From: [REDACTED]
Sent: 08 December 2025 11:39
To: Planning.Responses <Planning.Responses@arun.gov.uk>
Subject: Re: Please find attached acknowledgement of Planning Application Comment - R/215/25/HH

Town & Country Planning Act 1990 (as amended)
Town & Country Planning (Development Management Procedure) (England) Order 2015
Application No: R/215/25/HH
Site Address: 21 Sutton Avenue Rustington BN16 2ES
Description of works: Single storey rear extension.

Drawing:  
**Plans and elevations as proposed**

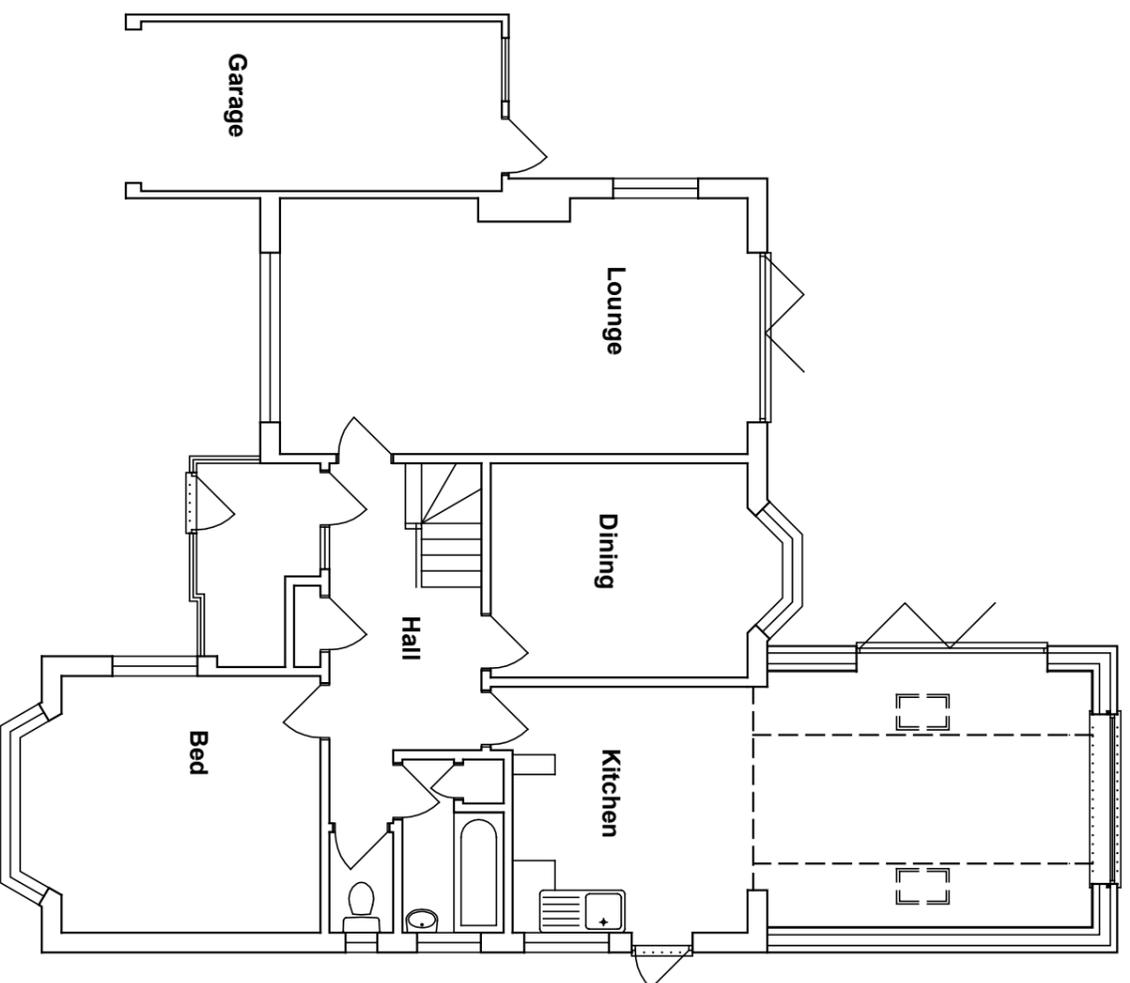
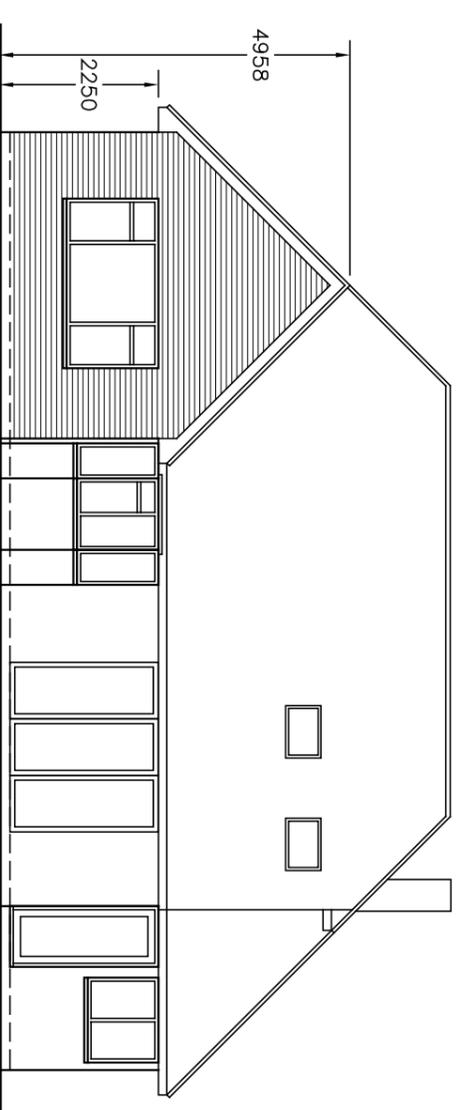
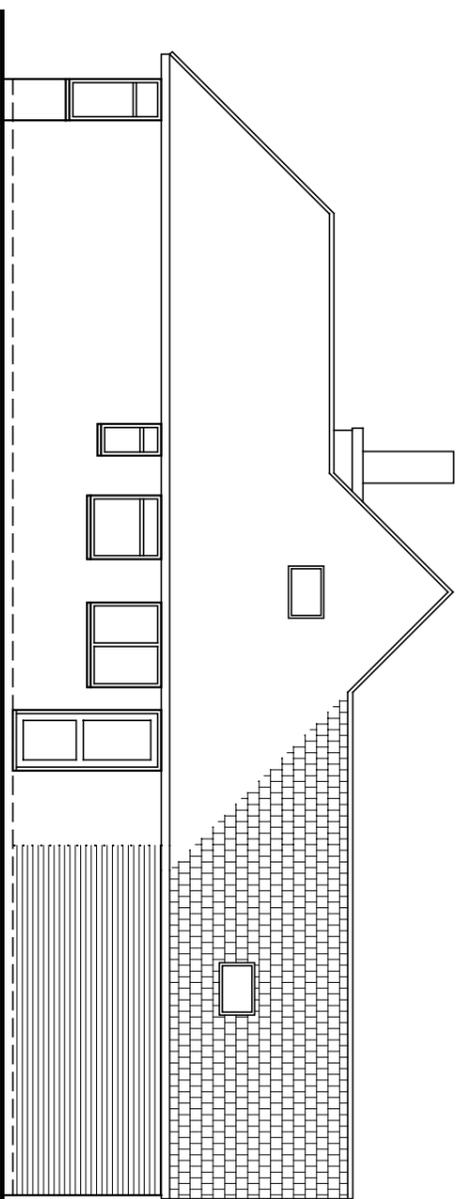
THOMPSONS EXTENSION ON MY SOUTH SIDE BORDER FULLS WITHIN A "45 DEGREE RULE" ANGLE TAKING MY CLOSEST WINDOW, ,LIVING ROOM ,CENTRE OF WINDOW

thompson family are trying to build within 45 degree angle you will see on their plans, which will block light heat push us both into dark
thank you from, please confirm you will add this new found evidence
j woods

THOMAS FAMILY PLAN TO BUILD EXTENSION /WALL/KITCHEN EXTENSION , ON MY SOUTH FACING BORDER WILL CAUSE A

PUSHING BACK MY HOME INTO RECESS, NOT IN KEEPING WITH NEIGHBOURHOOD , , MAIN LIVING AND OTHER AREAS OF HOME,

TILES FROM ROOF COULD BE DAMAGING IN BAD WEATHER , AS THEY WILL BE HEALTH HAZARD WHILE IN GARDEN, AND THREAT TO PROPERTY,

ALSO LIGHT FROM SKY RECESS INTERNAL LIGHT WOULD BE DIRECTLY INTO MY MAIN LIVING AREAS WHEN IN USE AT NIGHT
